Town & Country Planning Act 1990 (as amended)
Town and Country Planning (Development Management Procedure) (England) Order 2015
Approval of details reserved by condition imposed under ref WA/69/17/PL relating to Condition No
3,4,5,7,8,9
Progress Garage Yapton Lane, Walberton,

Condition Number 4

Arun District Council have decided to **REFUSE details reserved by condition for the following reasons:**

Drawing Title: Engineering Layout - Drainage, Levels and Contours

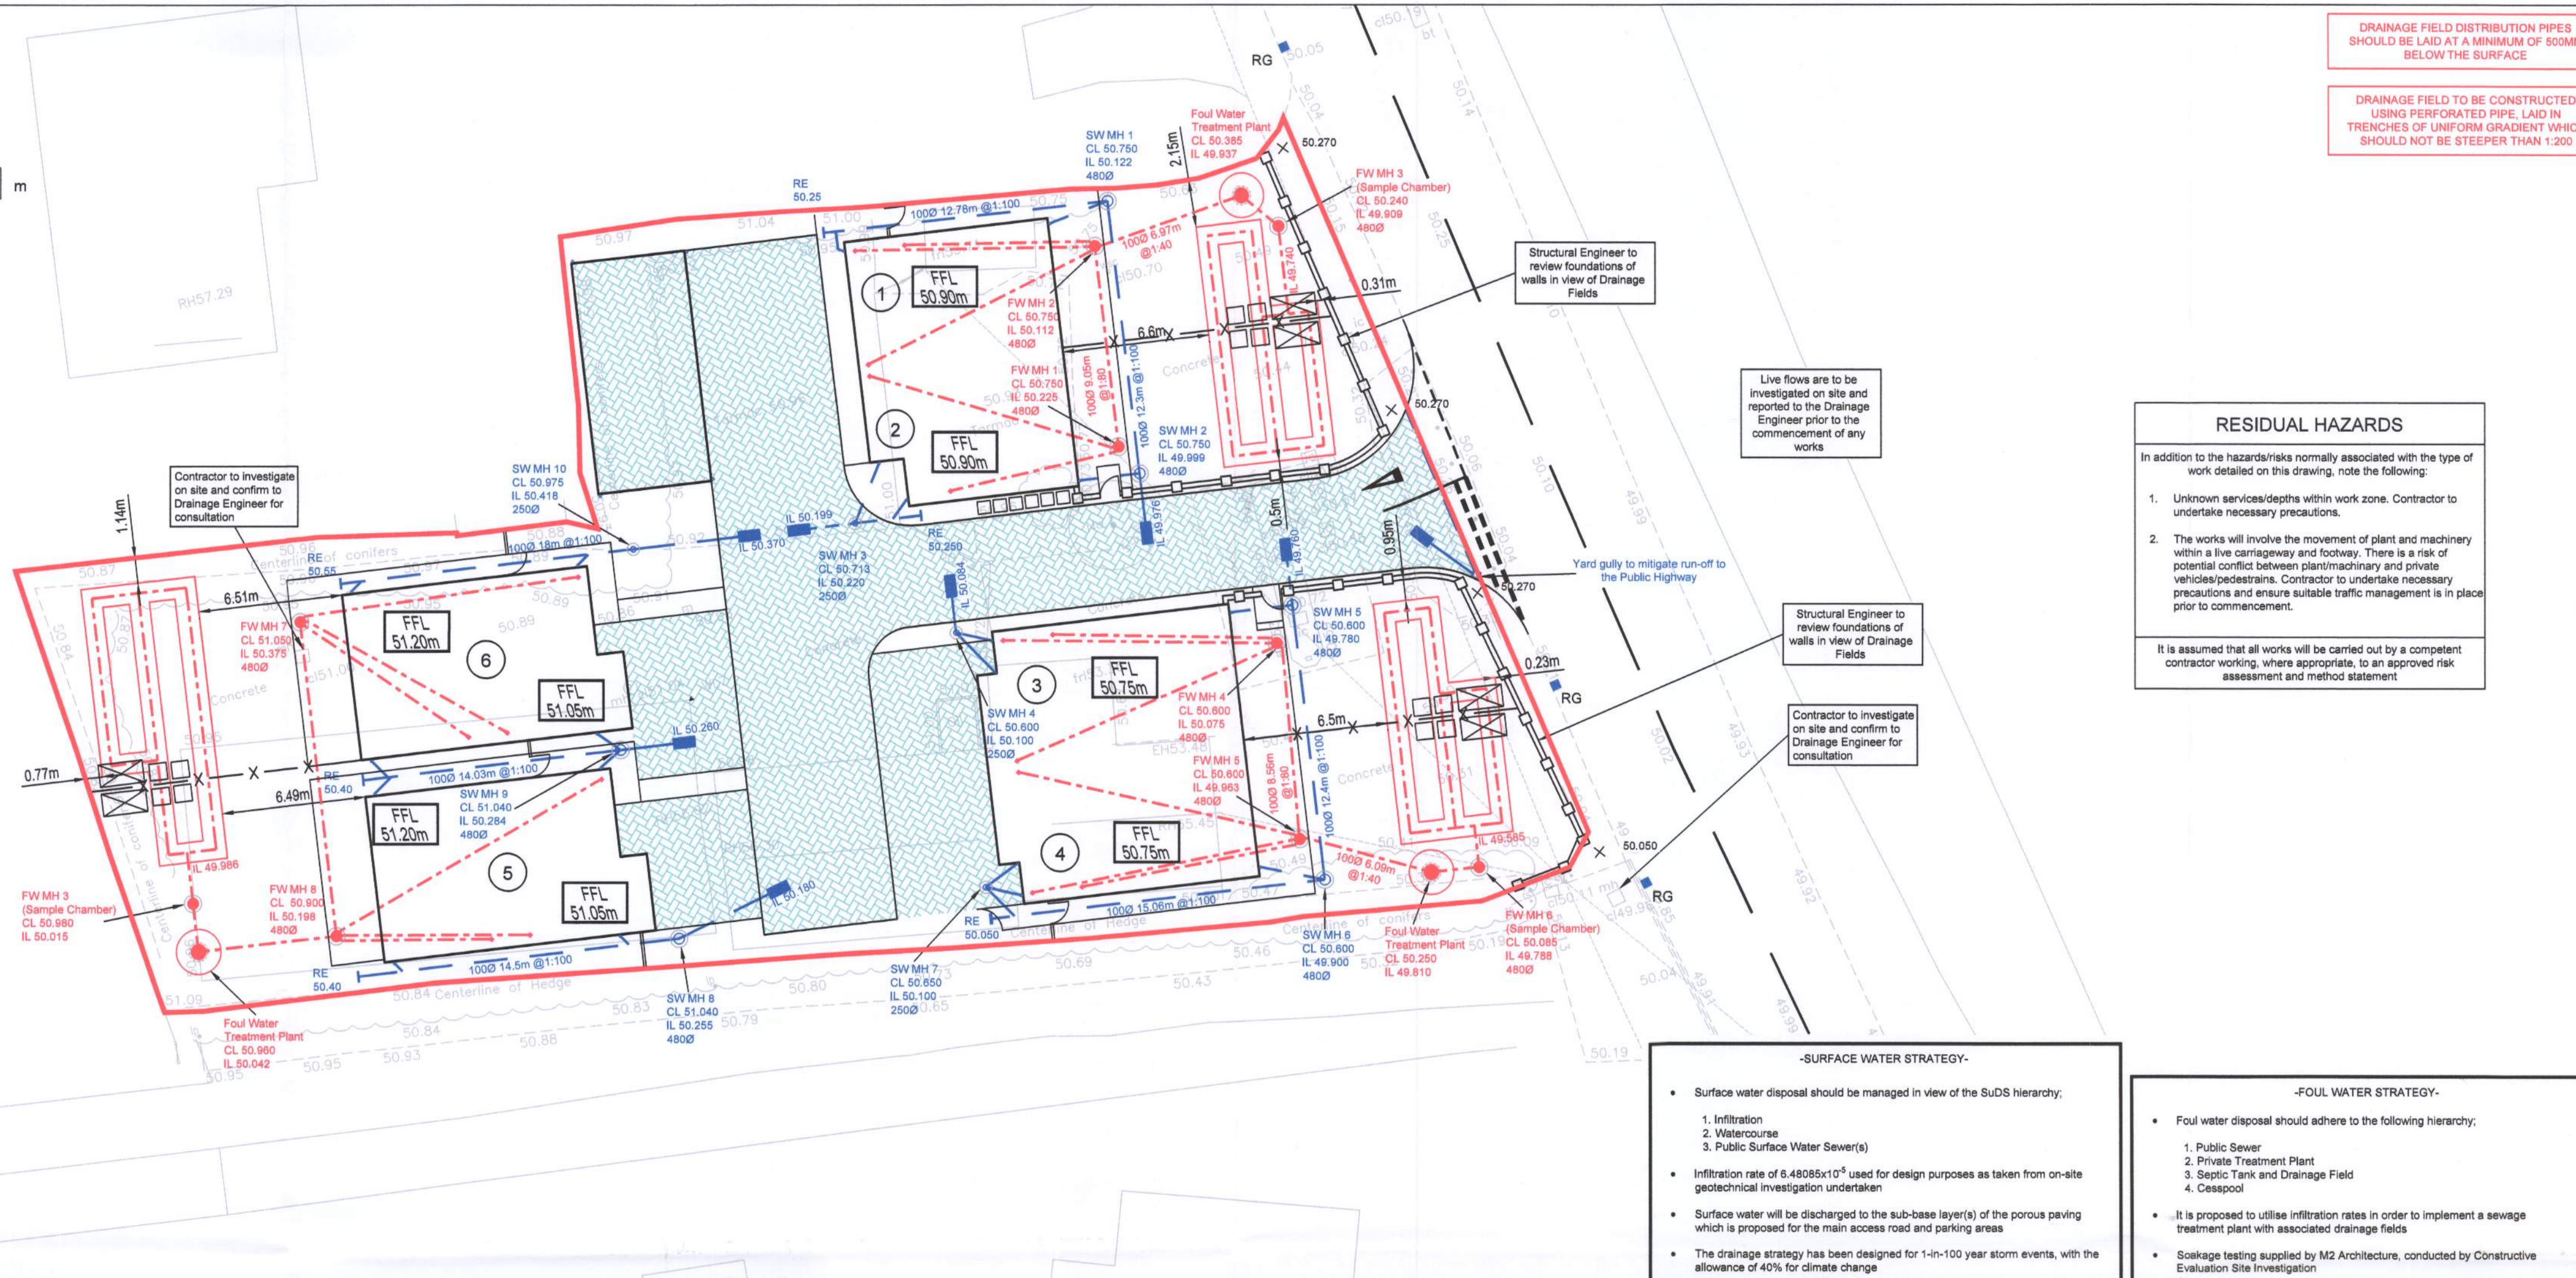
No plans, calculations, or construction details have been provided.

Winter infiltration testing and groundwater monitoring needs to be completed. Following this full detailed

calculations, plans and construction detail drawings should be submitted.

Soakaway Test Results & Soil Infiltration Rate

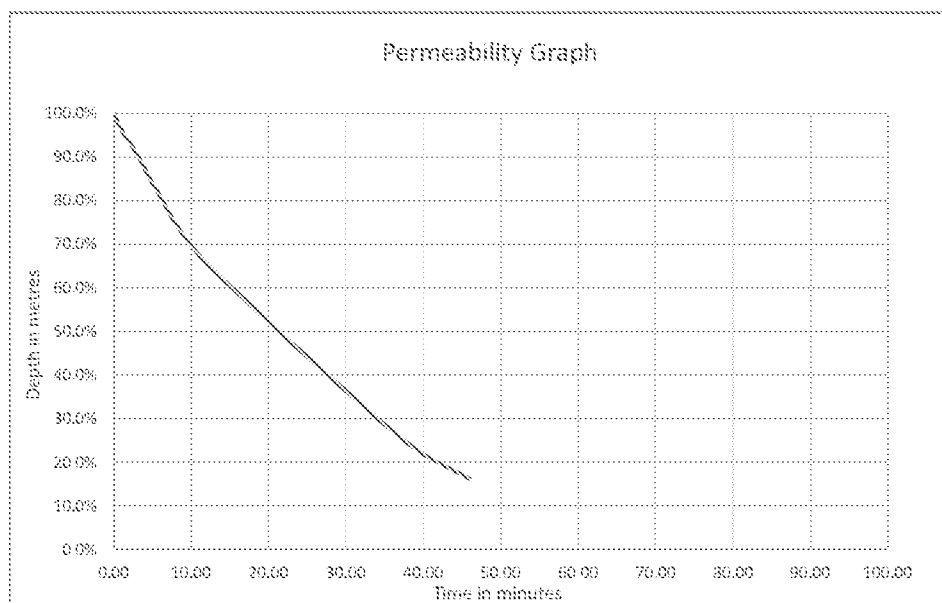
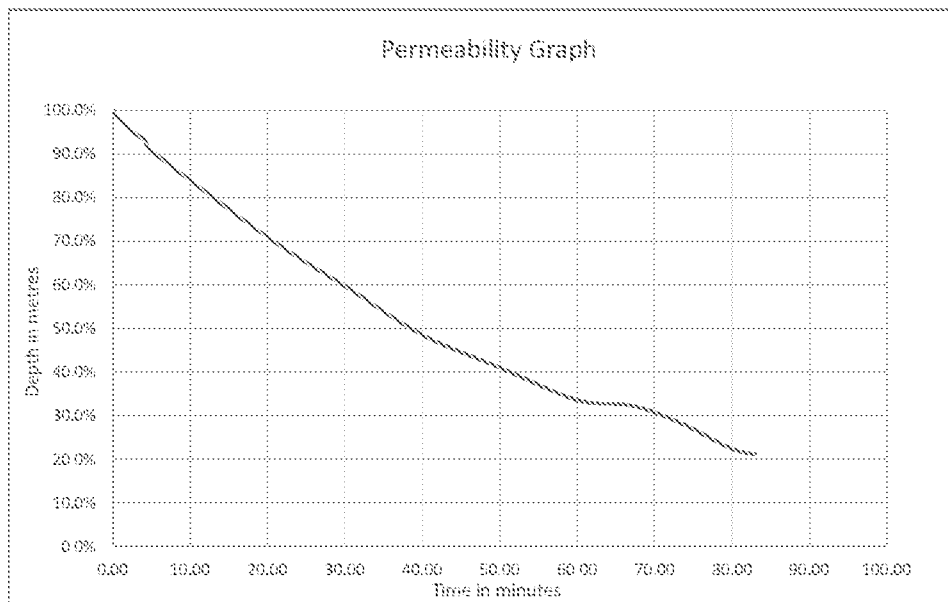
Discharge of this condition refused on the basis that Groundwater monitoring has not been completed October to March inclusive as is required for a development of this size.

No winter infiltration tests have been provided.
